## Development Facilitation Team (DFT) – Review Comments

**Project No: PR-2022-007299**    **Date: 7/3/2024**    **Agenda Item: #1**    **Zone Atlas Page: K-10**  
**Legal Description: LOTS 54 & 55 & 1, UNIT 6, TOWN OF ATRISCO GRANT**  
**Request: DFT – Site Plan Administrative for Skyview West Industrial**  
**Location: 7320 CENTRAL AVE SW between COORS and UNSER BLVD containing approximately 13.59 acre(s)**

### Application For: SI-2024-00931 – SITE PLAN DFT

**Project Name:** Site Plan Admin review for Skyview West Industrial – 7320 Central Ave SW, between Unser and Coors.

1 NORTH ELEVATION
1"=20'-0"

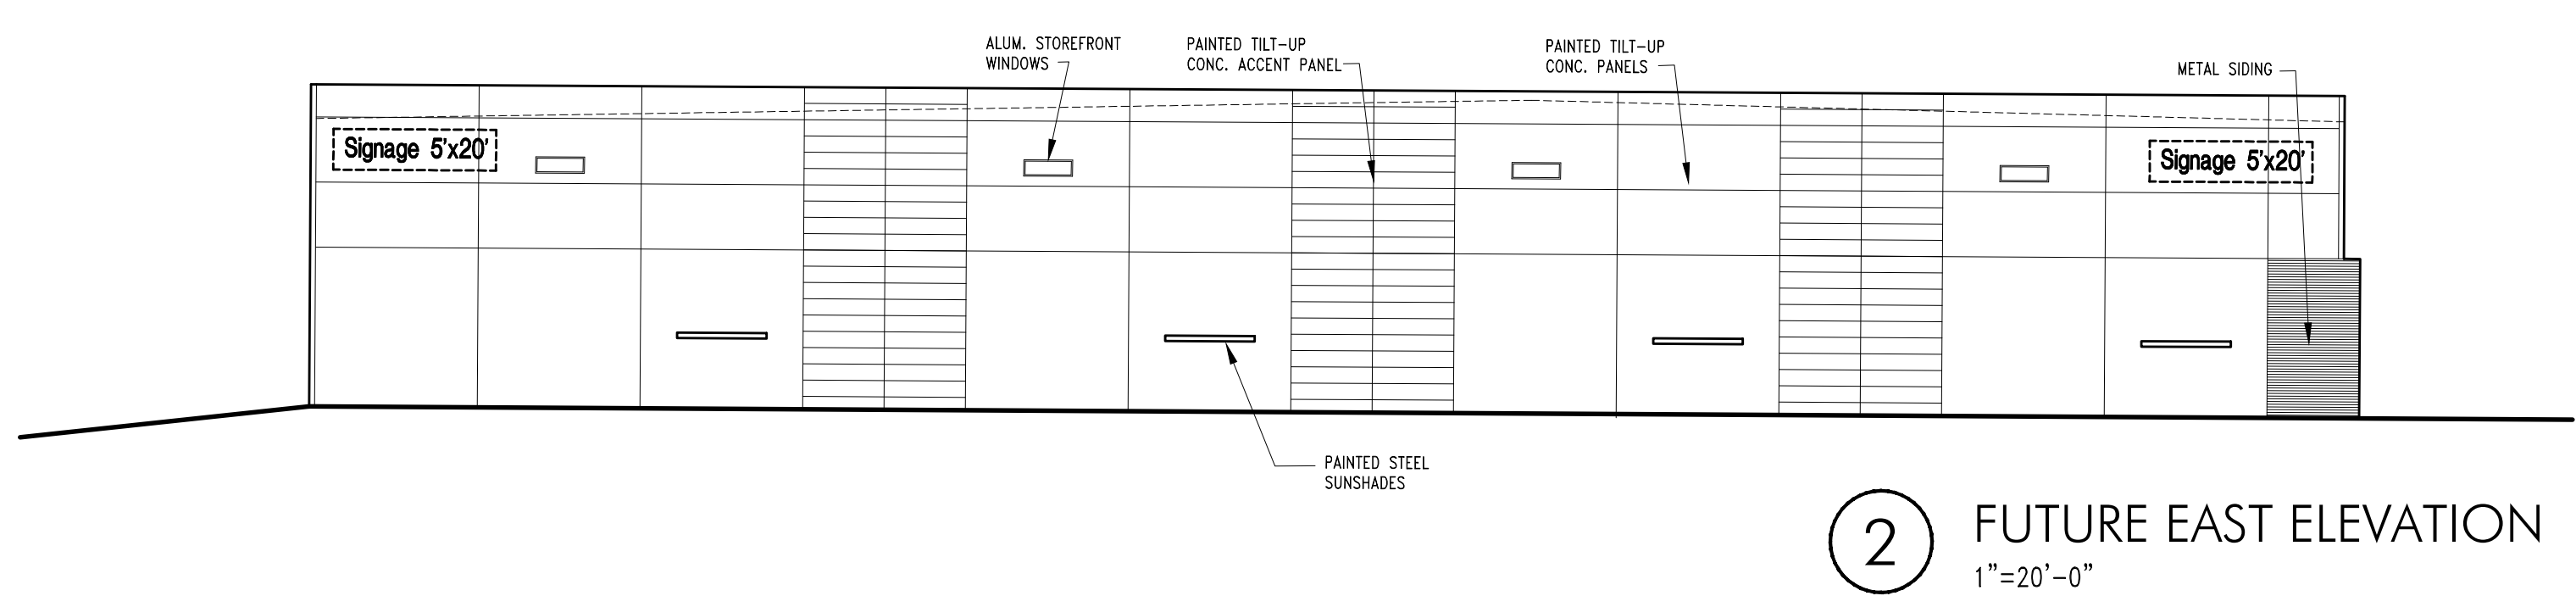
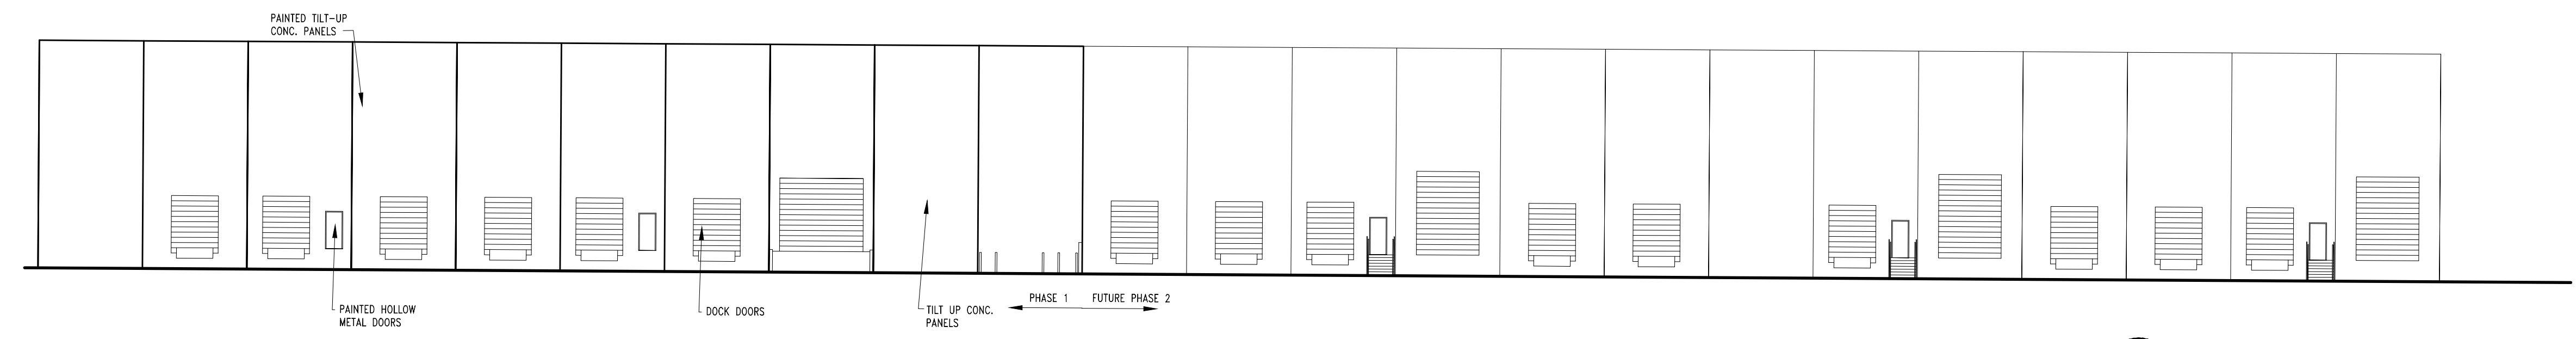
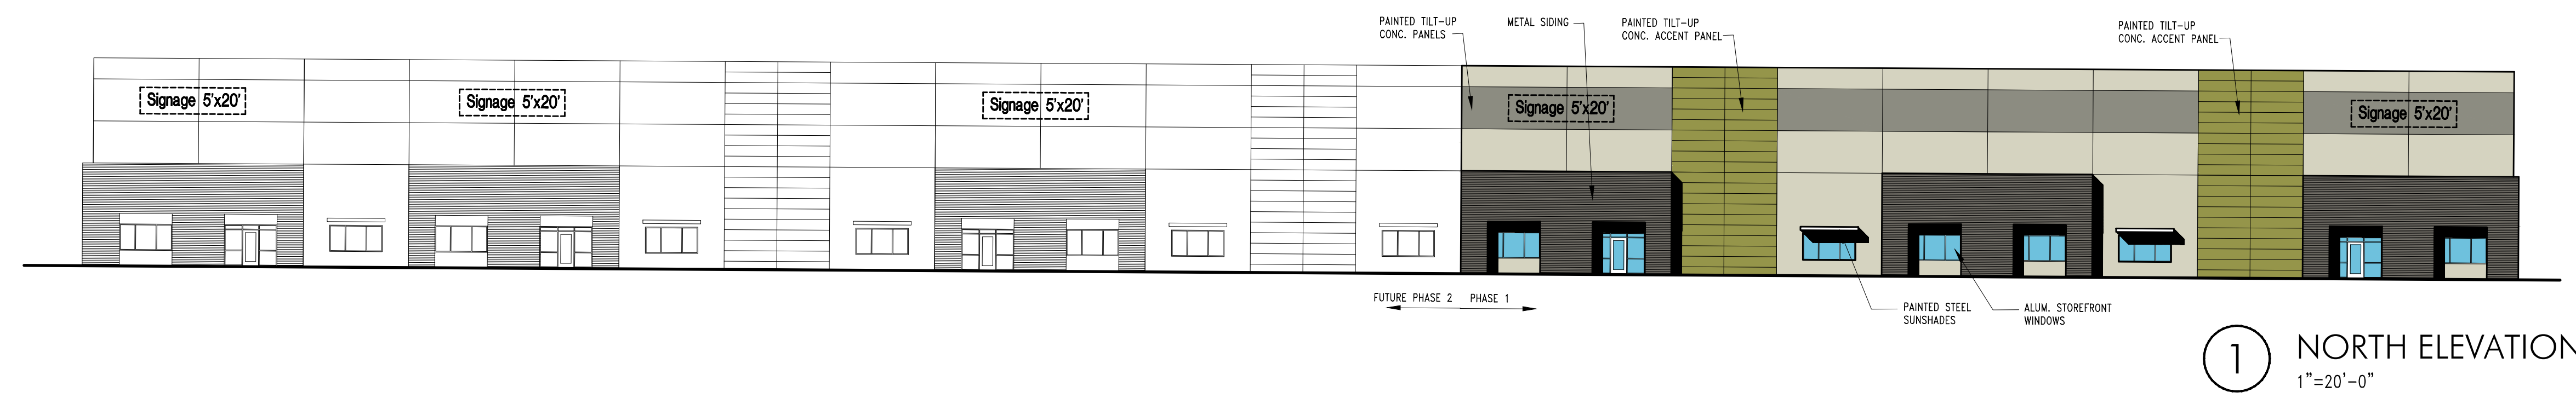
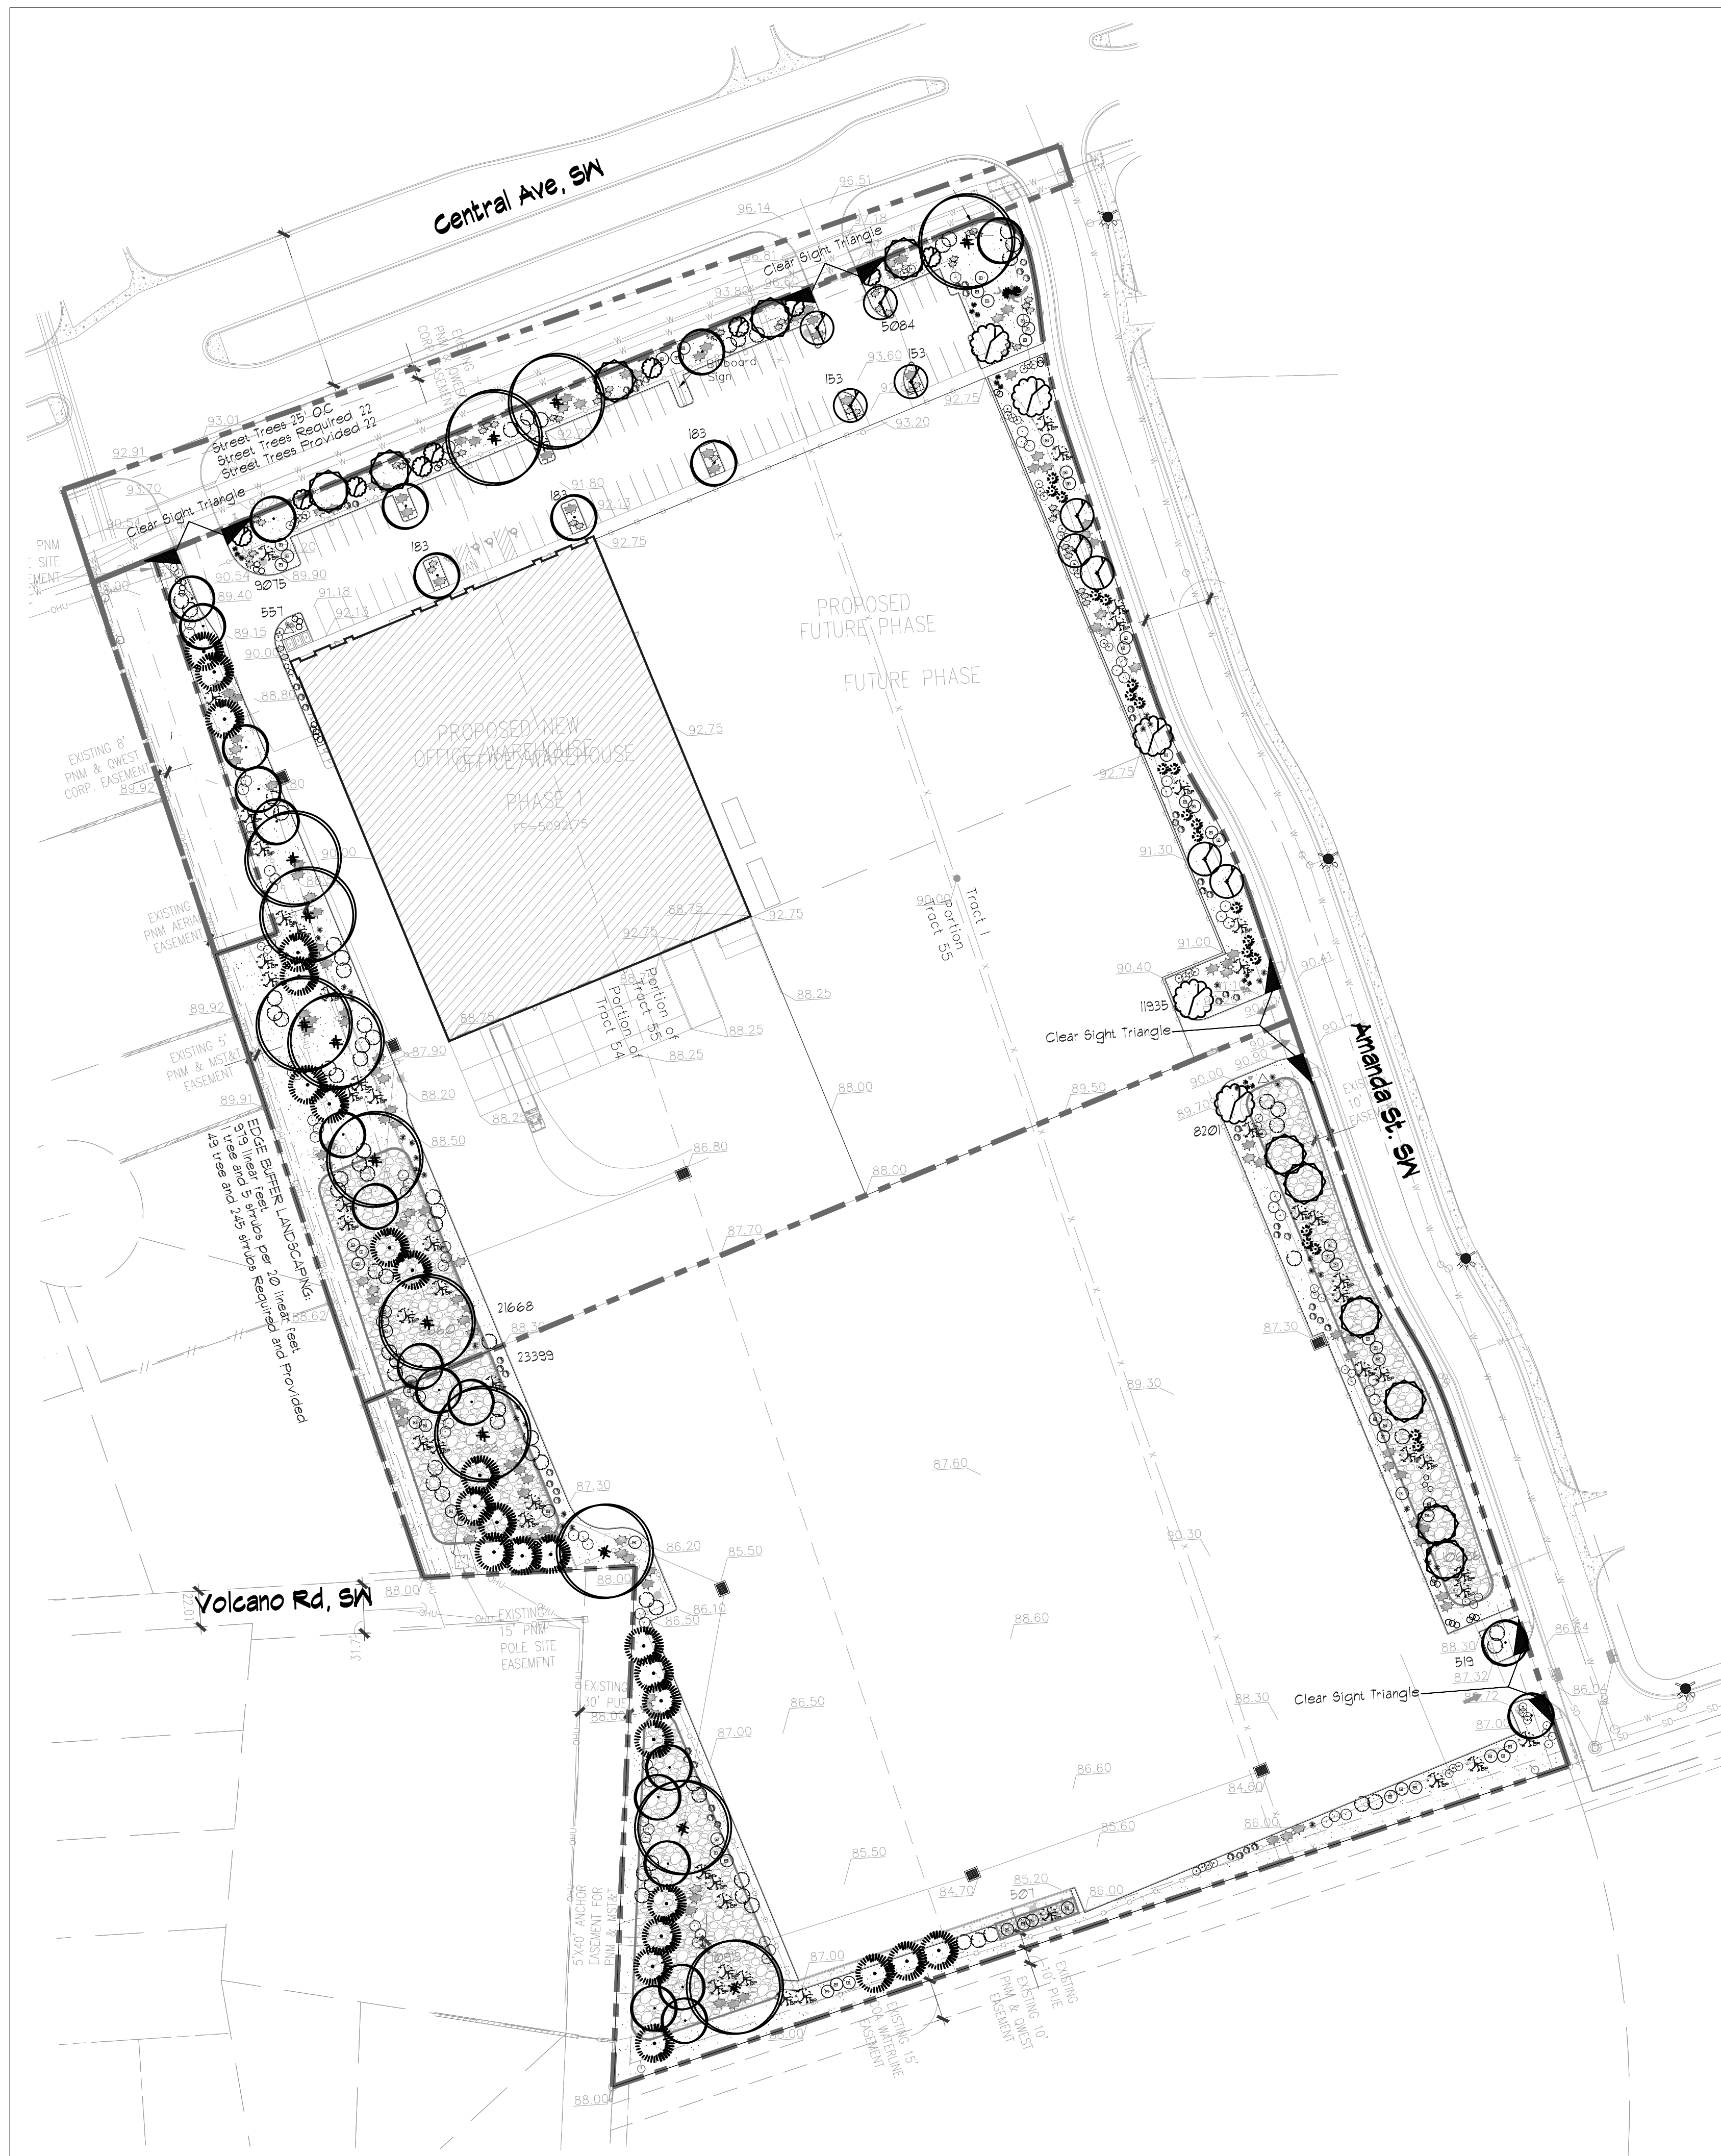
\*Elevation pages need to include measurements and dimensions. Such as height, windows, doors, changes in façade, Etc.

Provide detail to demonstrate and explain compliance with all sections within 5-11-E. Specifically 5-11-E-2 and 5-11-E-3.

RESPONSE- SEE REVISED ELEVATIONS FOR DIMENSIONS.

RESPONSE- ELEVATIONS COMPLY WITH IDO 5-11-E. SEE NOTE ON REVISED ELEVATIONS AND SITE PLAN.

DRAWN BY: FV
APPROVED BY: DM
Date: Jun 12, 2024
DRAWING
SHEET #
LS-101
PROJECT NO: 2024-093

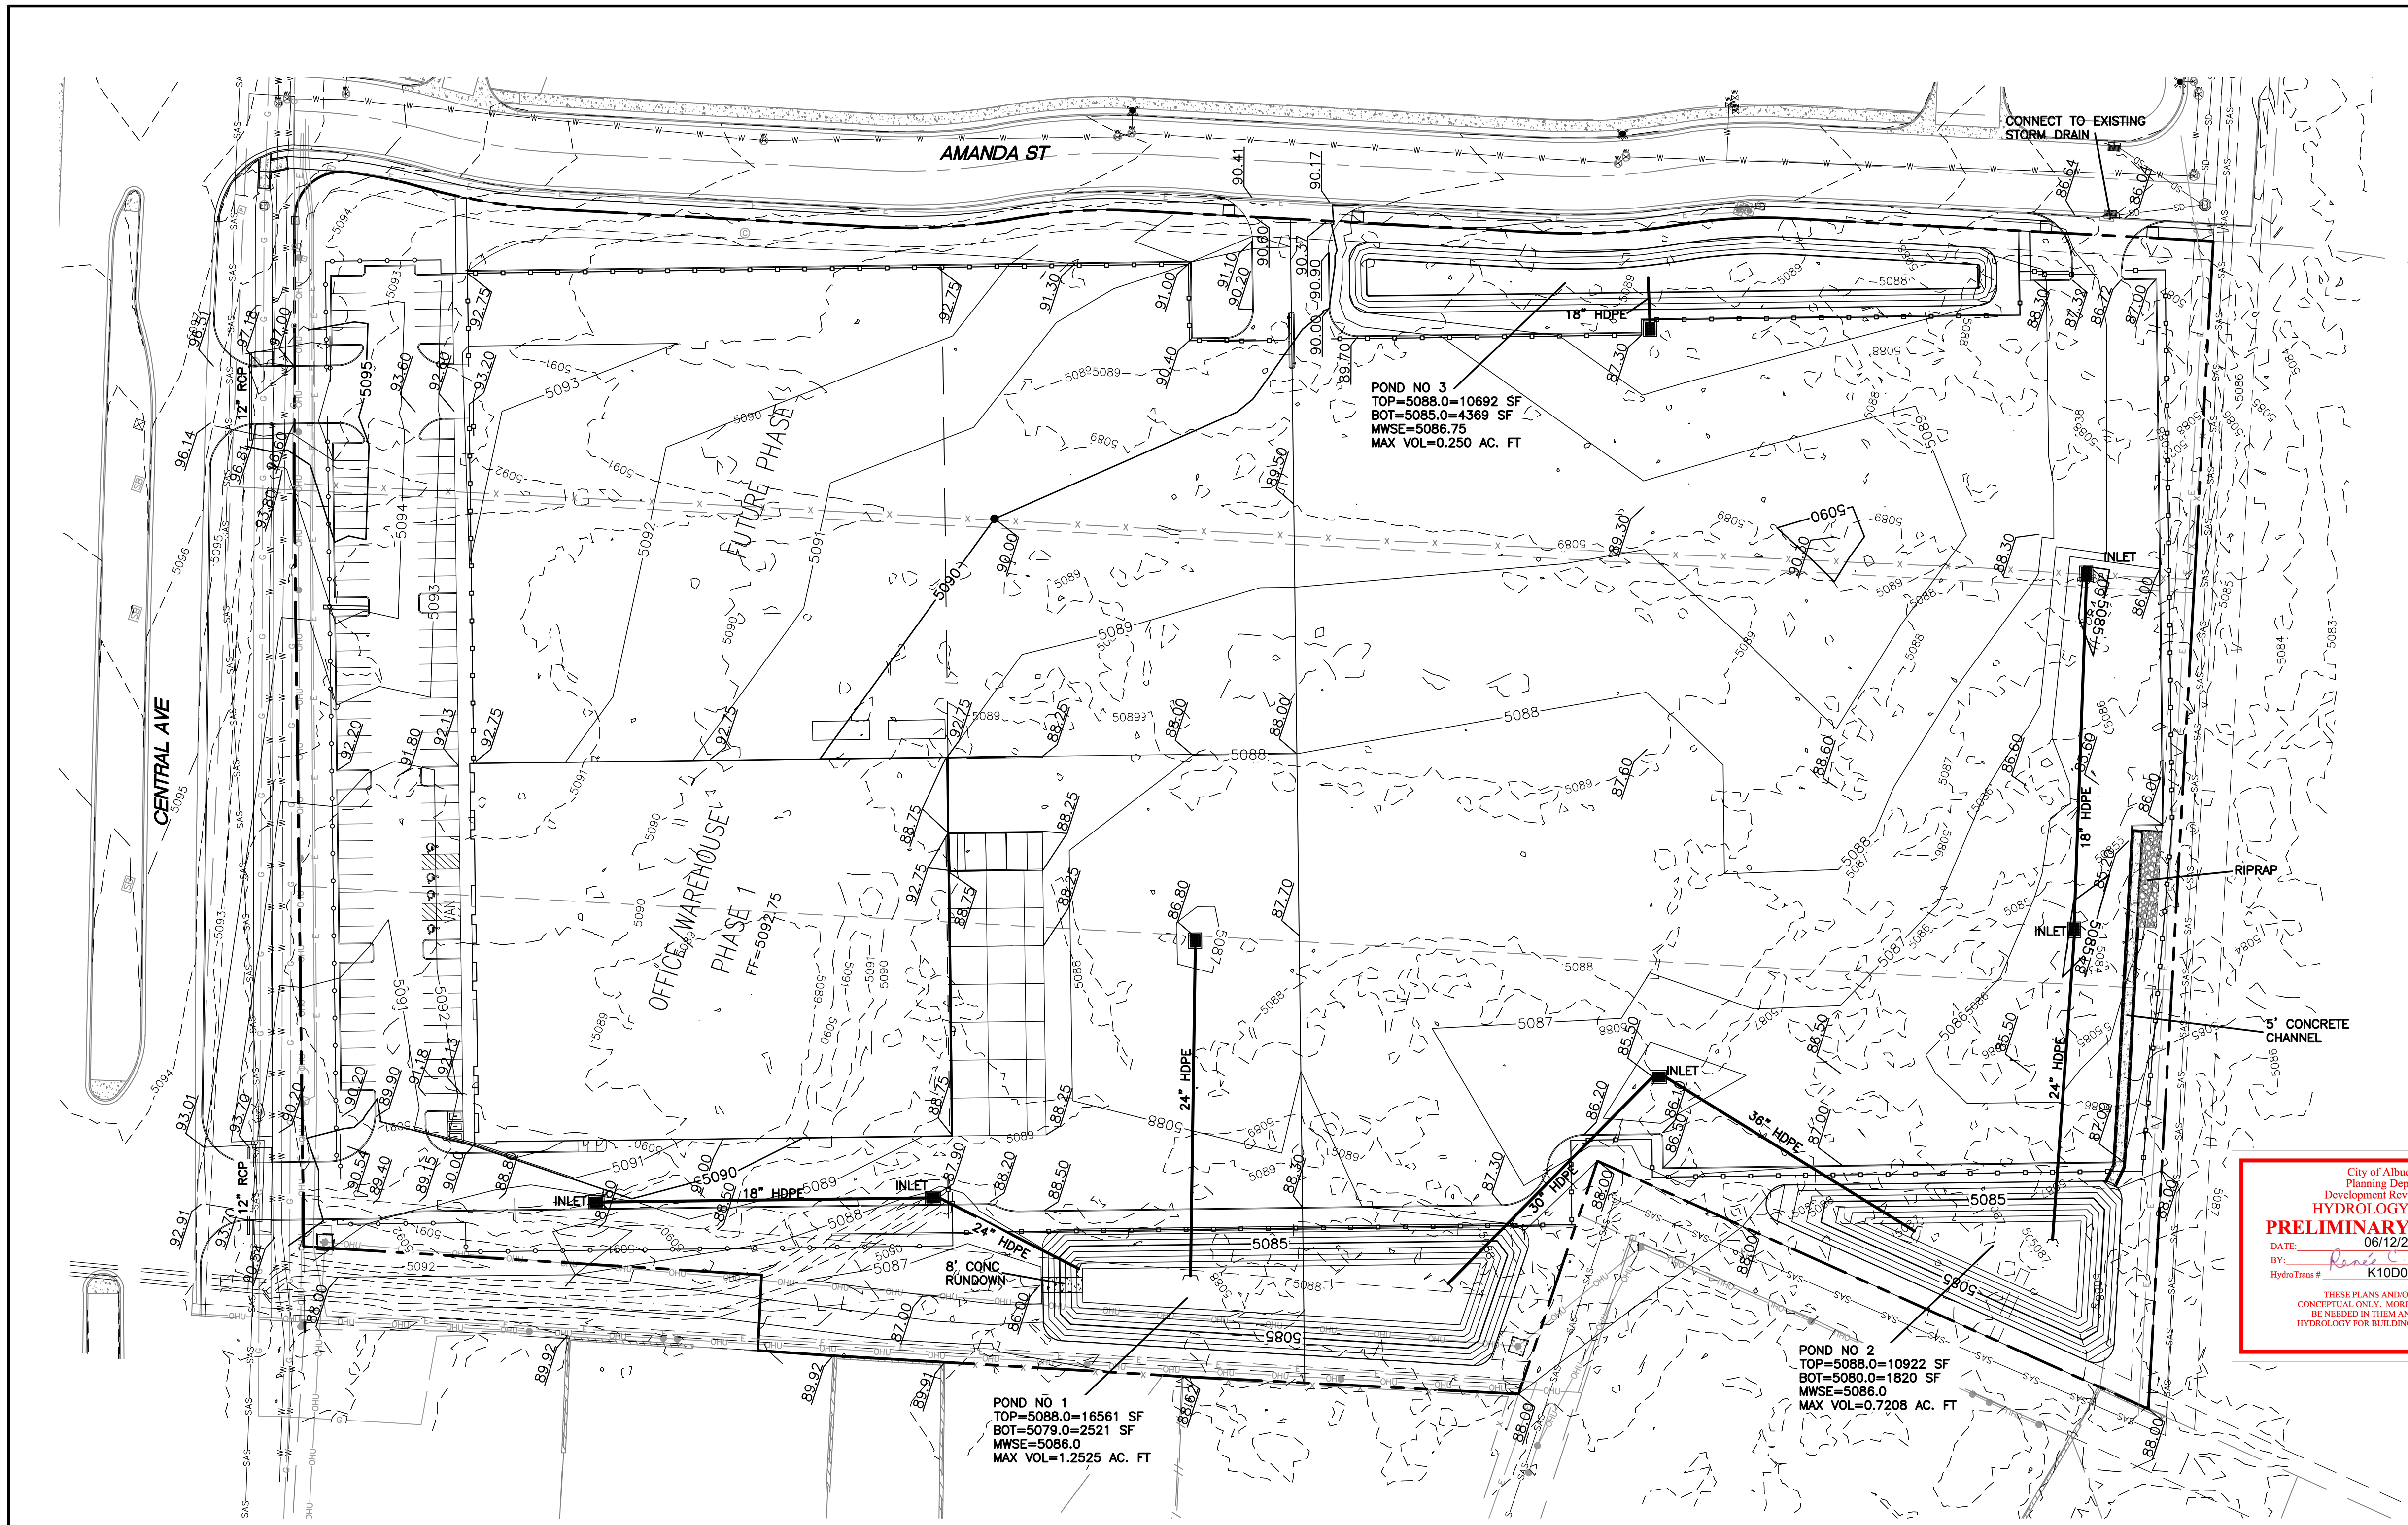
Provide relevant calculations and confirm compliance with this code. Additionally, the City of Albuquerque is in the process of eliminating non-functional turf grasses due to

high water requirements compared to the function they serve. Consider proposing a different plant material for these areas.

RESPONSE- NO TURF GRASSES PROPOSED. SEE ATTACHED REVISED LANDSCAPE PLAN FOR CALCULATIONS AND CONFIRMATION OF COMPLIANCE WITH THIS 5-6(C)(4)(d)
